CITY OF ALBUQUERQUE
PLANNING DEPARTMENT
April 30, 2014
DRB Comments

PROJECT # 1010051

APPLICATION # 14-70112

RE: Lots 1D-1 & 1-D-2, Block 1 Airport Industrial Park

# PLAT OF LOT 1-D-1-A, BLOCK 1 AIRPORT INDUSTRIAL PARK

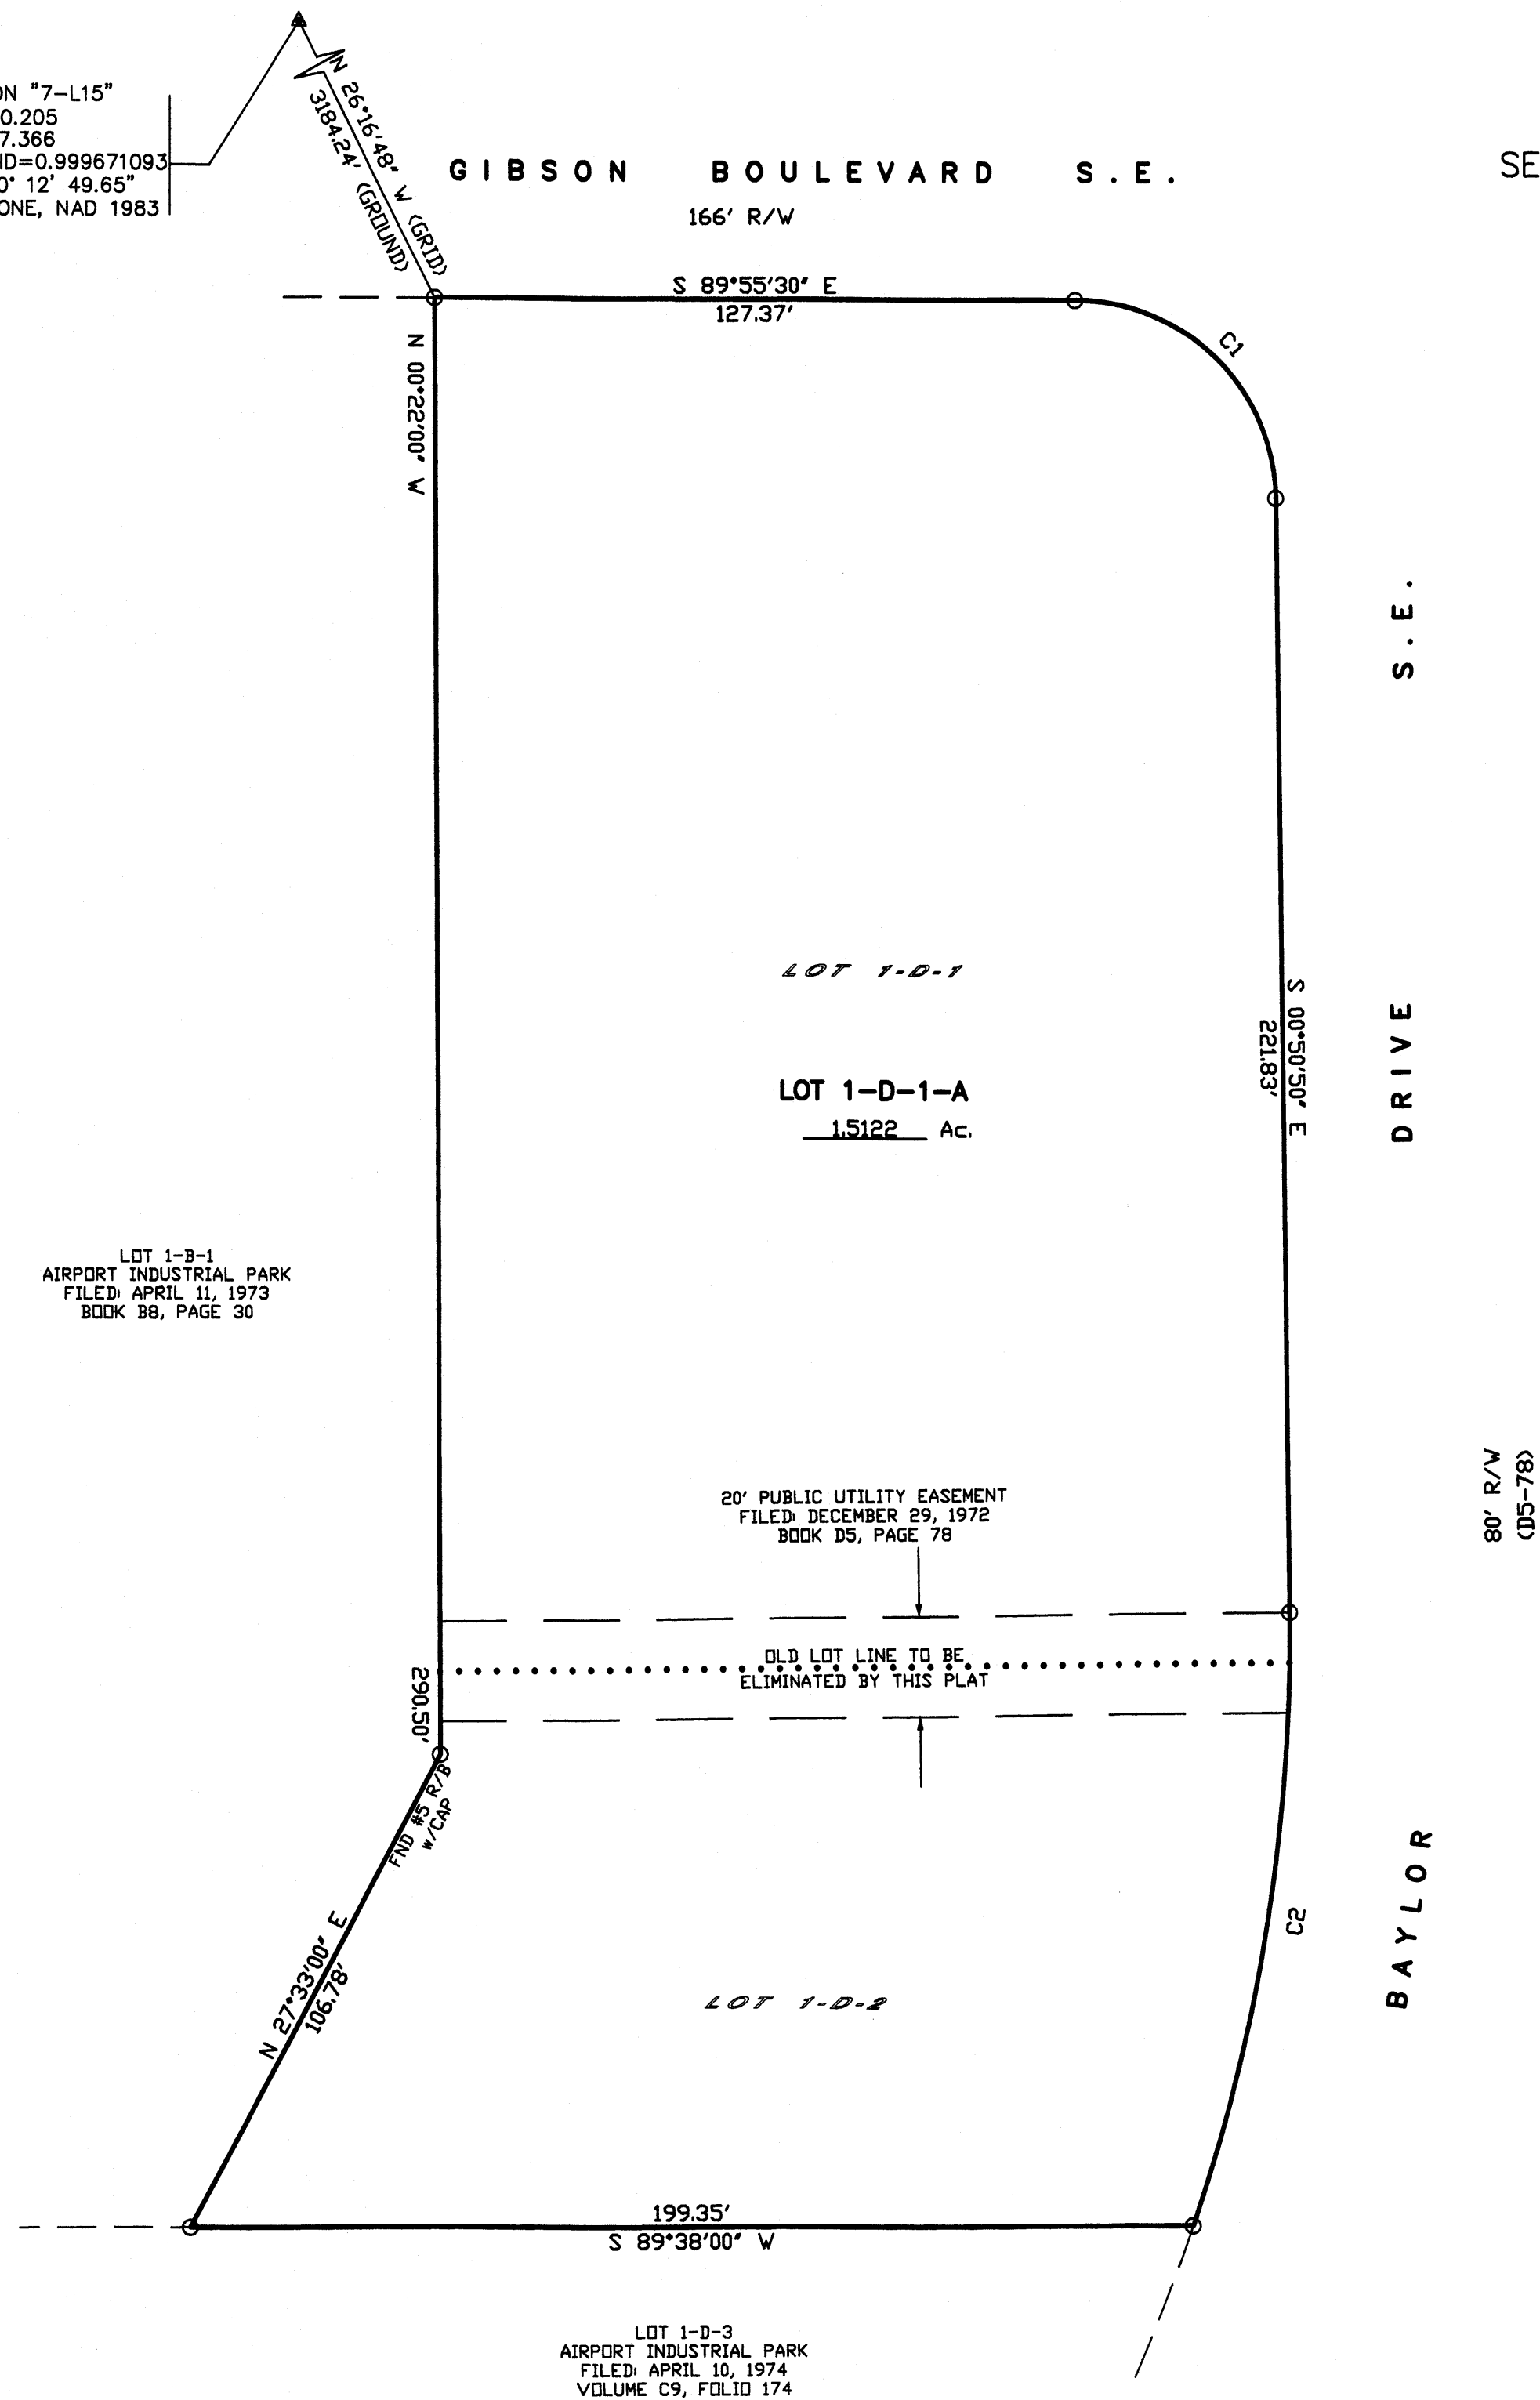
It appears additional right of way as well as completion of the sidewalk for the cul de sac on Baylor is needed – refer to comments from Transportation Development.
